APEX WASTE SOLUTIONS - 560-570 AIR LANE

SITE DEVELOPMENT PLAN

PCD File PPR2441

APEX WASTE SOLUTIONS - 560-570 AIR LANE

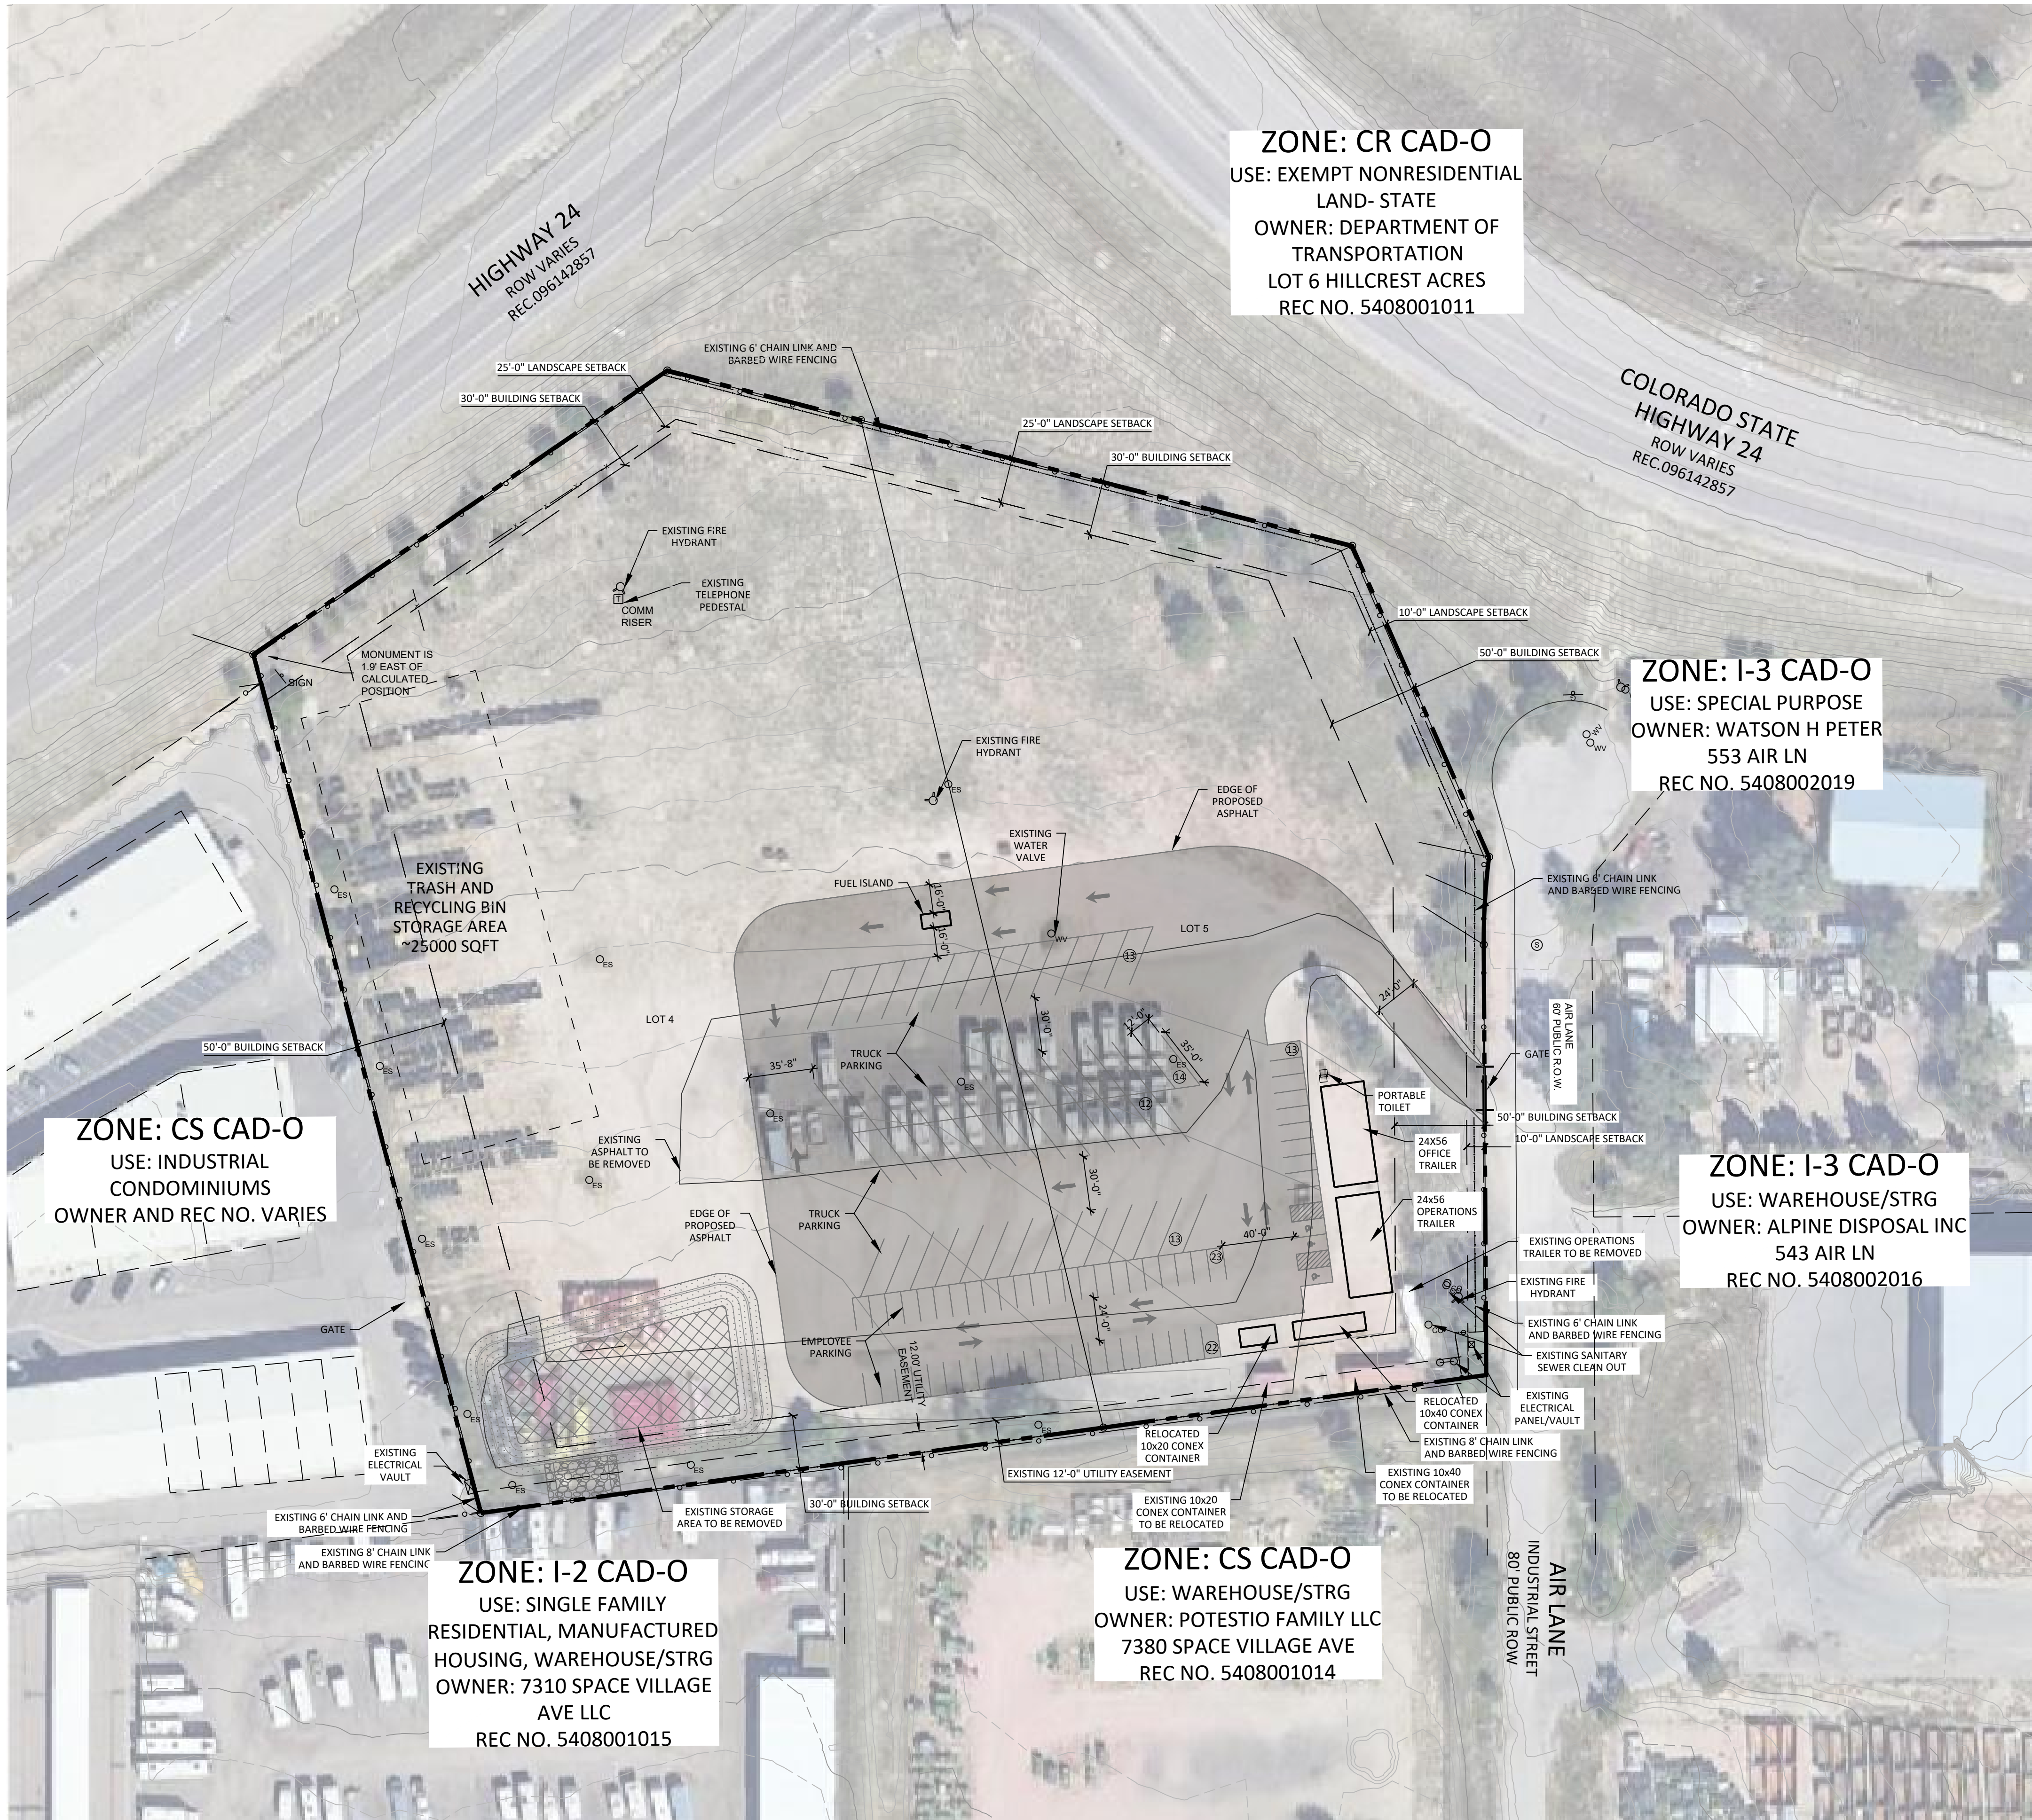
combine to one single note -line return error

address is unclear. What address is this refer to?
